27 April 2018

SF2017/037839; WST17/00033/02

SSD6456: Narrabri Gas Project; Response to Submissions (RtS)

Source: Austroads Guide to Road Design – Part 4A: Unsignalised and Signalised Intersections - Figure 8.3

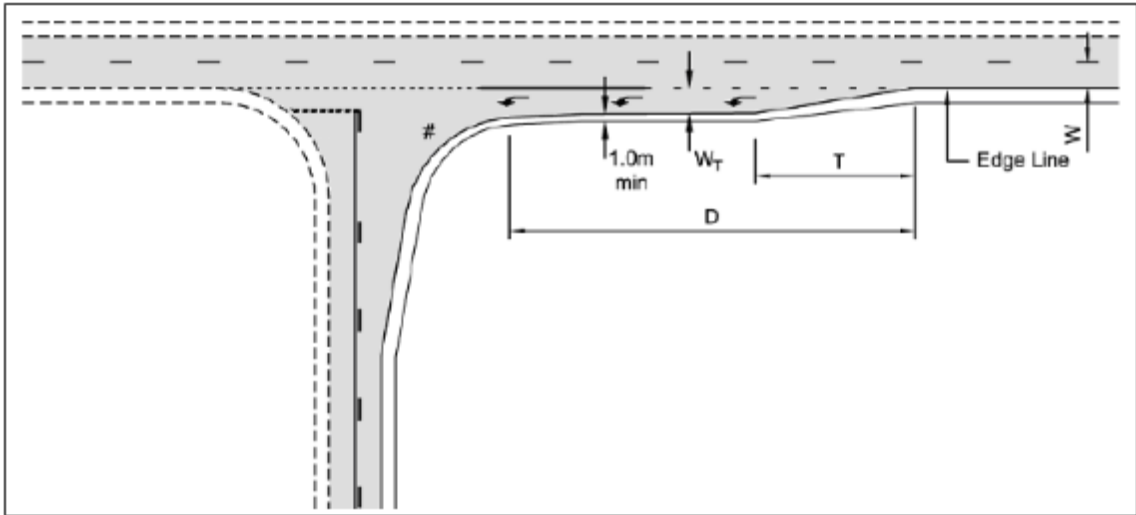
- The applicant has advised the proposed upgrade of the X-Line Road and Newell Highway (HW17) intersection will meet Roads and Maritime's requirements. However, the applicant has used the acronym for a Basic Left (BAL) turn treatment and then referenced the required Auxiliary Left turn Short [AUL(s)] treatment. To be clear, Roads and Maritime recommends the intersection of the Newell Highway and X-Line Road be upgraded to include sealed AUL(s) and Basic Right (BAR) turn treatments in accordance with Figures 8.3 & 7.5 of *Austroads Guide to Road Design 2010* and relevant Roads and Maritime supplements.

- The applicant notes *the current intersection (X-Line/Newell Highway) arrangement does not provide a formed shoulder wide enough to be considered as a BAR treatment as indicated in Figures 8.3 and 7.5 of Austroads Guide to Road Design*. Roads and Maritime's advice to the Department on 20 April 2017 recommends the applicant upgrade the intersection to include BAR and AUL(s) treatments – this includes construction of road (widening) to accommodate the treatments. Please note Figure 8.3 relates to the left turn [AUL(s)] treatment and not the BAR.
